CITY OF ALBUQUERQUE

September 23, 2021

Re: US Electrical Corporation
314 Arizona St SE
Traffic Circulation Layout
Architect's Stamp 09-20-2021 (K18-D092A)

Based upon the information provided in your submittal received 09-22-2021, the above referenced plan cannot be approved for Building Permit until the following comments are addressed:

ADA STANDARDS
A1.1 1/4" = 1'-0"

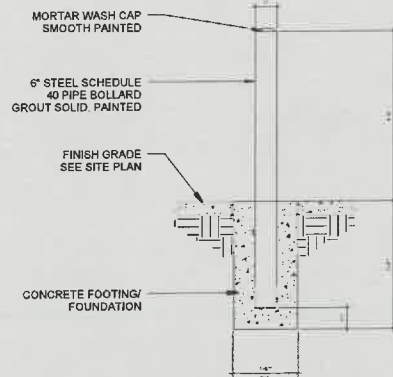
2. ADA curb ramps must be updated to current standards and have truncated domes installed at the corners of Acoma/Arizona and Acoma/California. **Provide COA Std dwg number for these ramp update.**

SIDWALK DETAIL
A1.1 3/4" = 1'-0"

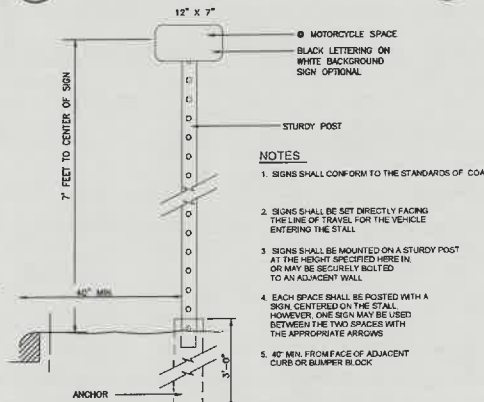
5. All sidewalks along public streets:
 - Sidewalk are required and should be placed at the property line.
 - **Please provide construction note to build sidewalk include limits and COA Std Dwg 2430.**

8. Add a note stating "All broken or cracked sidewalk must be replaced with sidewalk and curb & gutter." **A build note must be provided referring to the appropriate City Standard drawing (2430 & 2415A).**

SITE PLAN
A1.1 1" = 20'-0"

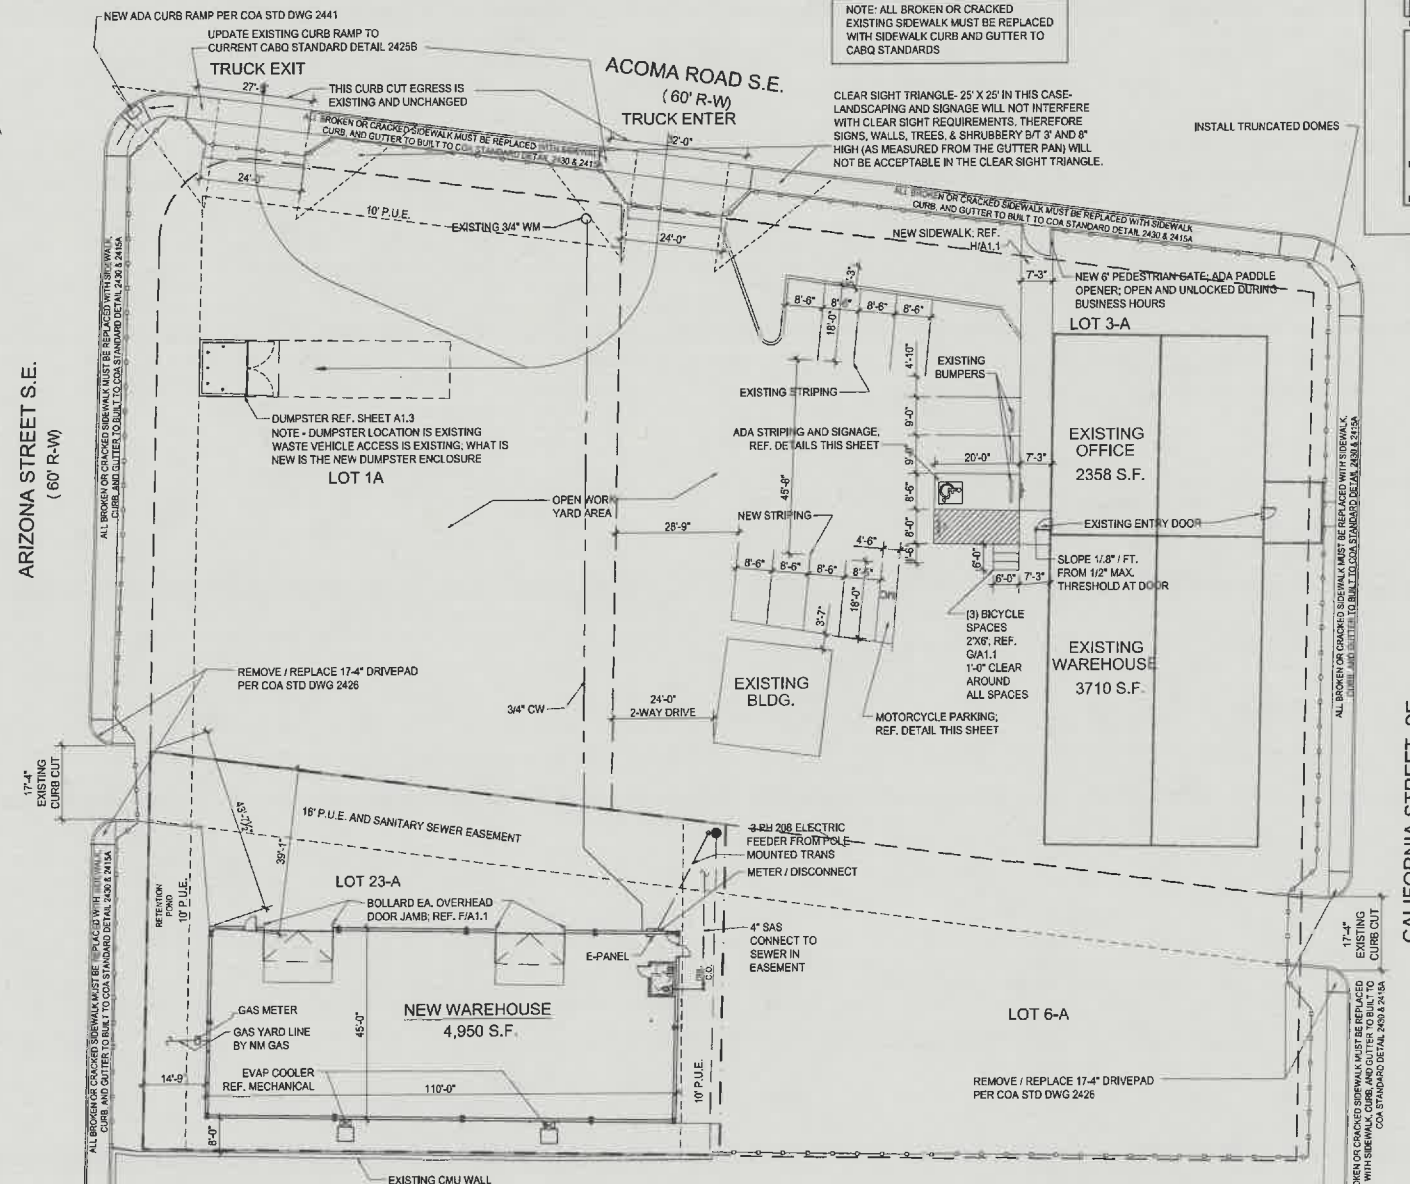
#- The stall provided is only 8.0' and needs to be 8.5" in width.

3. All existing drivepads fronting Acoma and Arizona must be updated to current standards. Verify the ADA access across these entrance driveways. **Provide COA std dwg number to update to current ADA standards.**

4. Per the IDO, a **6 ft. wide ADA accessible pedestrian pathway** is required from the public sidewalk to the building entrances. **You provided a 5 ft wide gate pedestrian gate off Acoma buy it needs to be 6 ft wide.** Please adjust.

7. Shared Site acces: driveways that straddle property lines, or are entirely on one propertybut are to be used by another property, shall have an access easement. **Please include a copy of your shared access agreement with the adjacent property owner.**
